Rose Hill Farm, Whalley Old Road, Billington

Transport Note

Address: Smalleys Farm House, Whalley Old Road, Billington

Proposal: New access on Whalley Old Road to serve existing dwelling

Proposed Site Plan
Scale 1:500

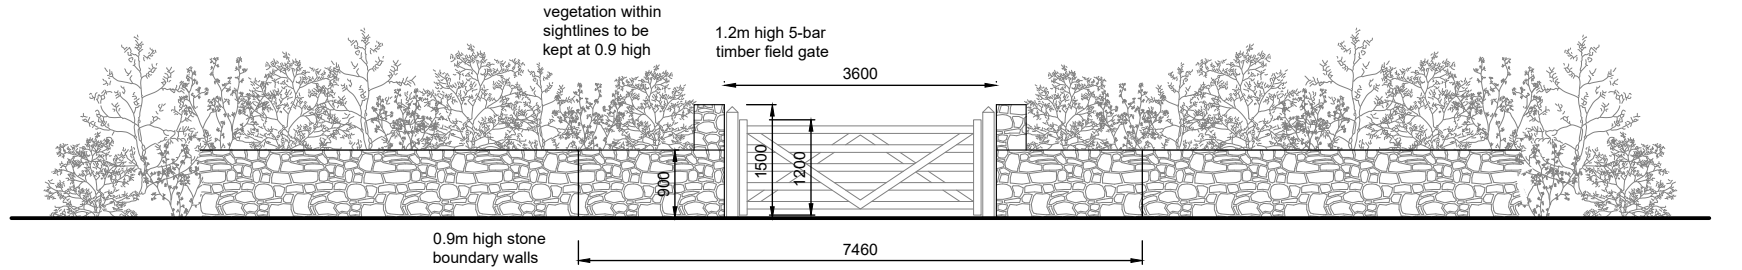
The access is proposed to be 3.8m wide with new stone walls around the radius and with gates set back by 6m from the carriageway edge. The verges adjacent to the carriageway are recorded as highway for an approximate width of 2.5m - 3m, therefore

no structures, walls, etc should be constructed and the proposed new walls will need amending. (Extract of record below)

There is an extract of the public footpath definitive plan below, note that the line shown on your drawing differs from the record. The record should be used to advise the design.

However, we do not support the construction of stone walls at the access on the highway and would request that this element is removed from the scheme.

ADOPTABLE HIGHWAY LAYOUT

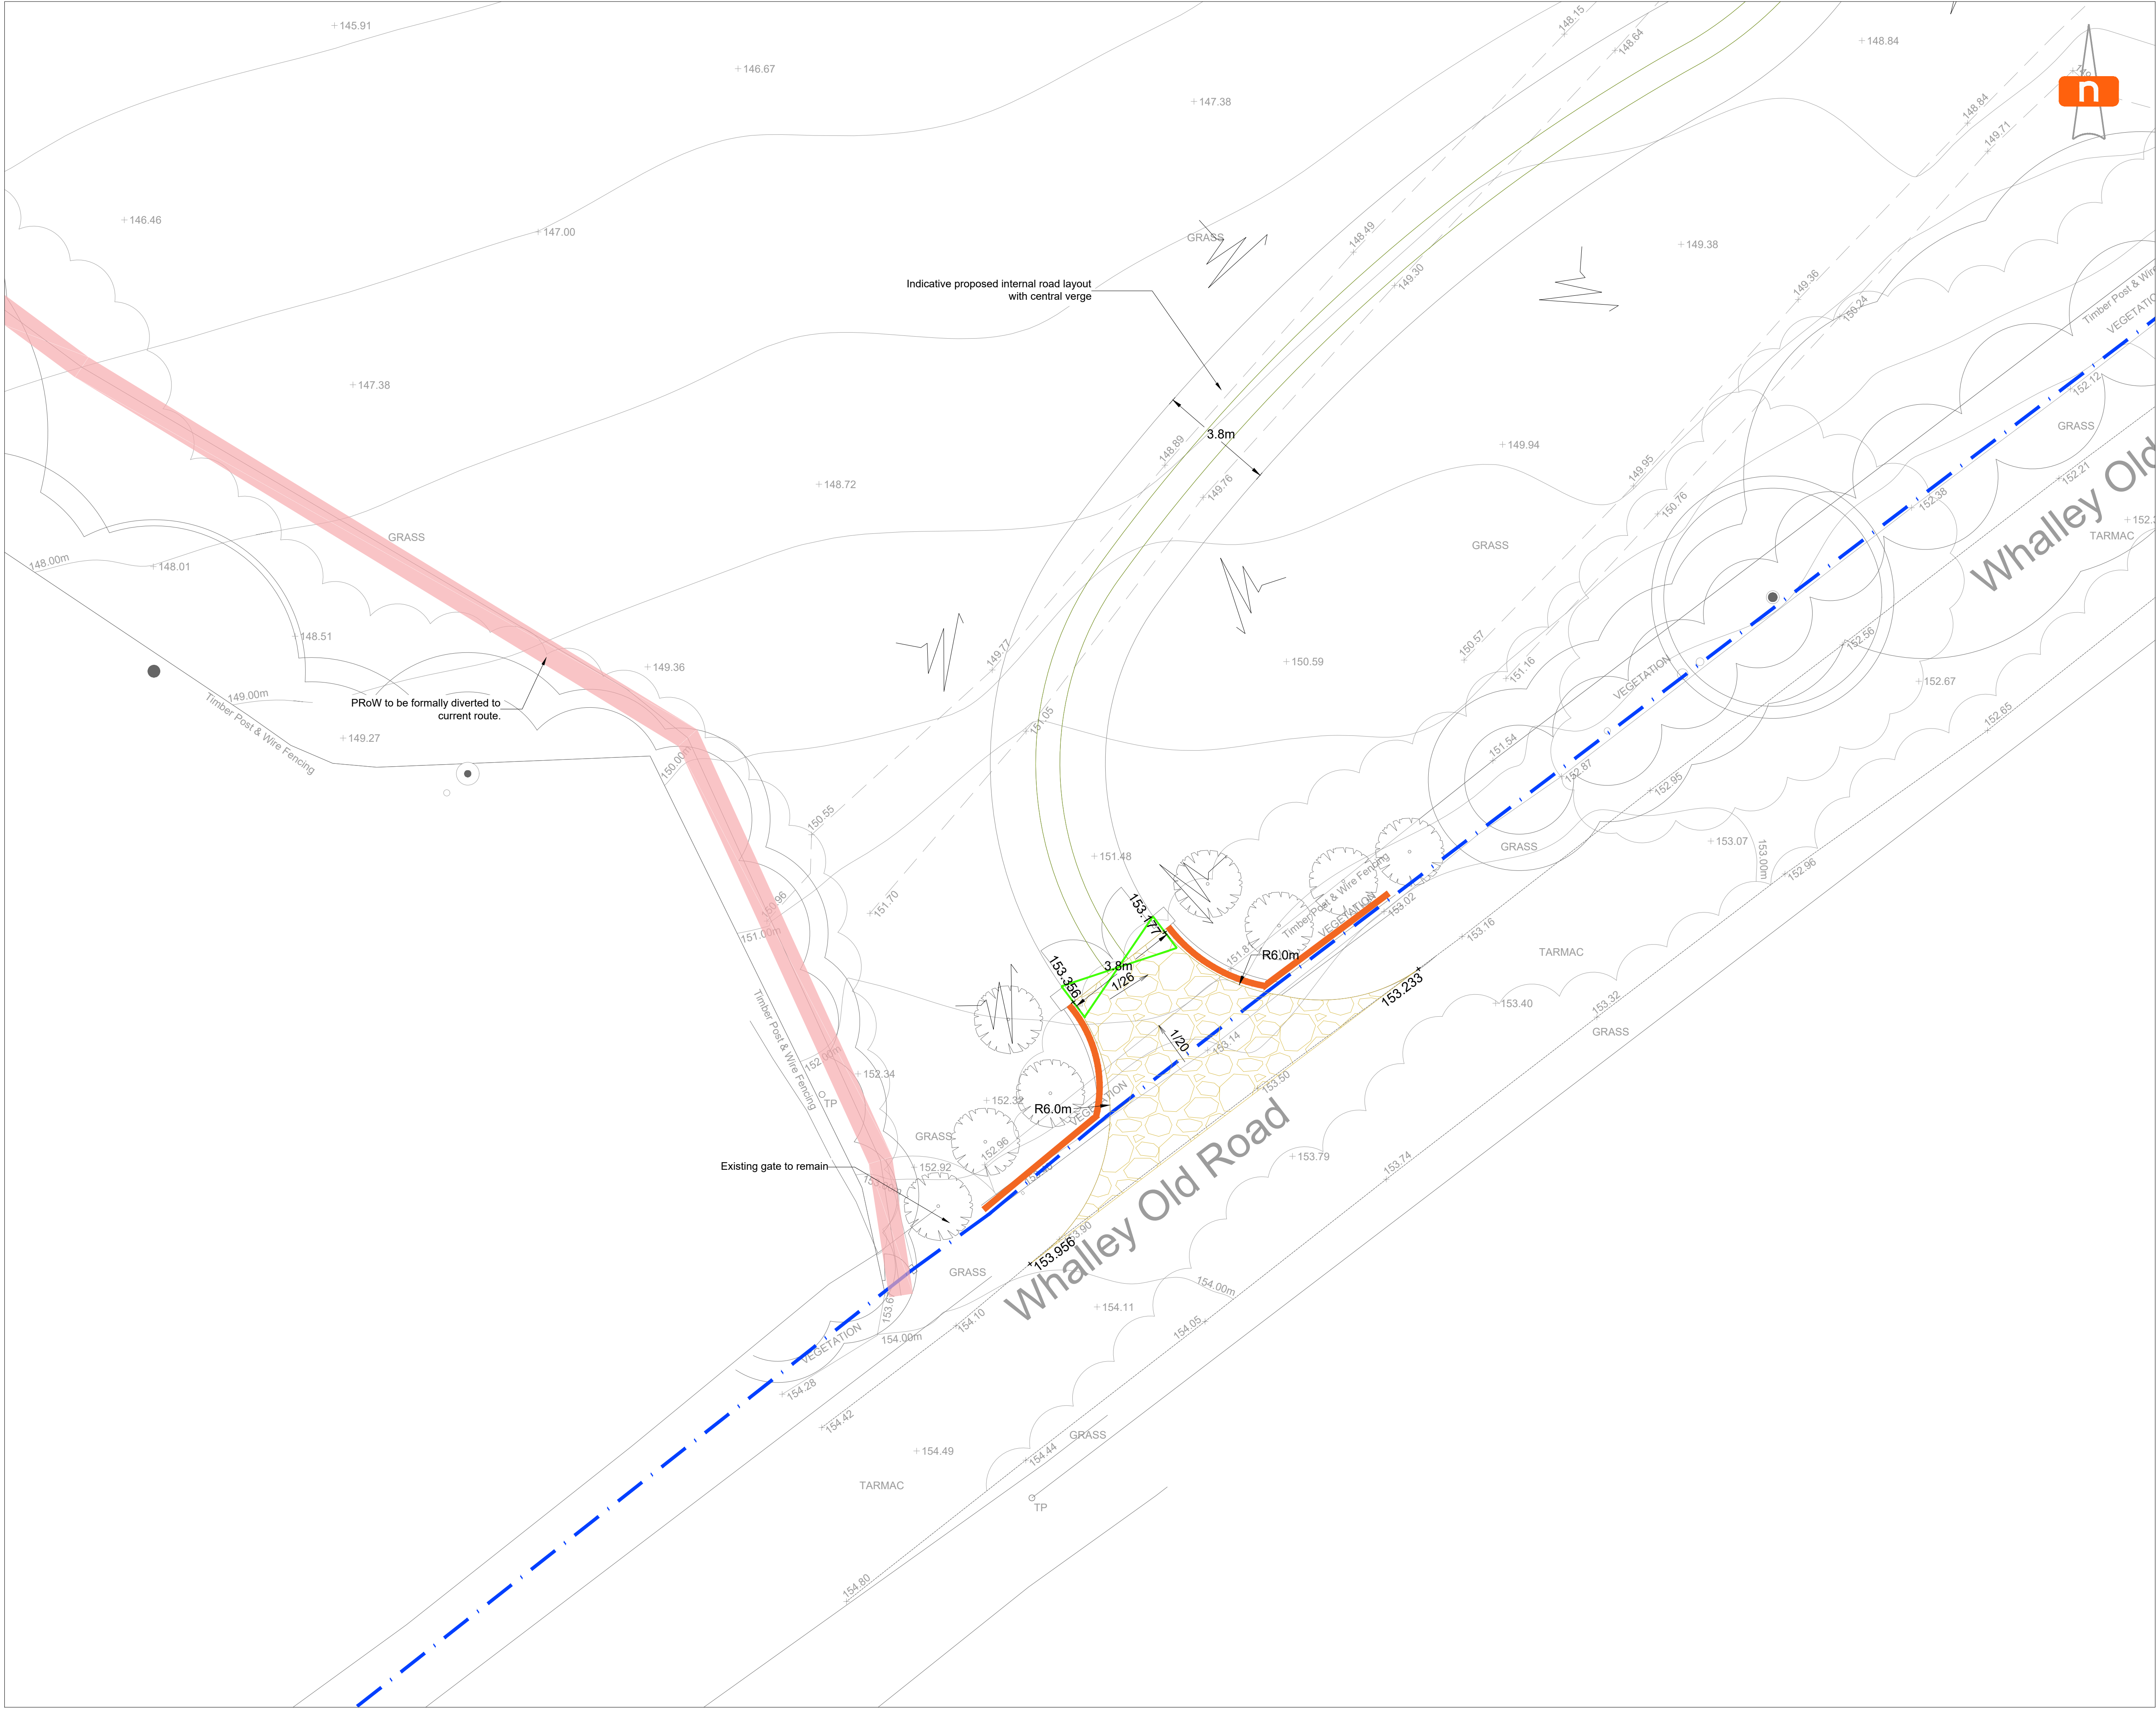
An access and visibility splay drawing is submitted and demonstrates splays of X2.4m by Y145m to the northeast side and Y180m to the southwest side of the nearside carriageway edge. The X distance can be reduced from 2.4m to 2m for a single or small number of dwellings and the Y distance can be offset by 1m from the carriageway edge. This will slightly increase the splays in both directions. These splays lie within land controlled by the applicant or the highway.

The full visibility splay requirement for a 60mph speed limit is 214m however the 85thile speeds on Whalley Old Road are likely to be less than the speed limit. The proposed splays are suitable for 85thile speeds of 50 – 55mph which is considered suitable.

The access road between the carriageway of Whalley Old Road and the gates should be paved in a bound material and laid at a gradient not exceeding 1:20. The carriageway edge should be saw cut straight and sealed to ensure a suitable tie-in detail to the paved highway. Surface water drainage should be included to ensure that no water is drained onto the highway or vice versa.
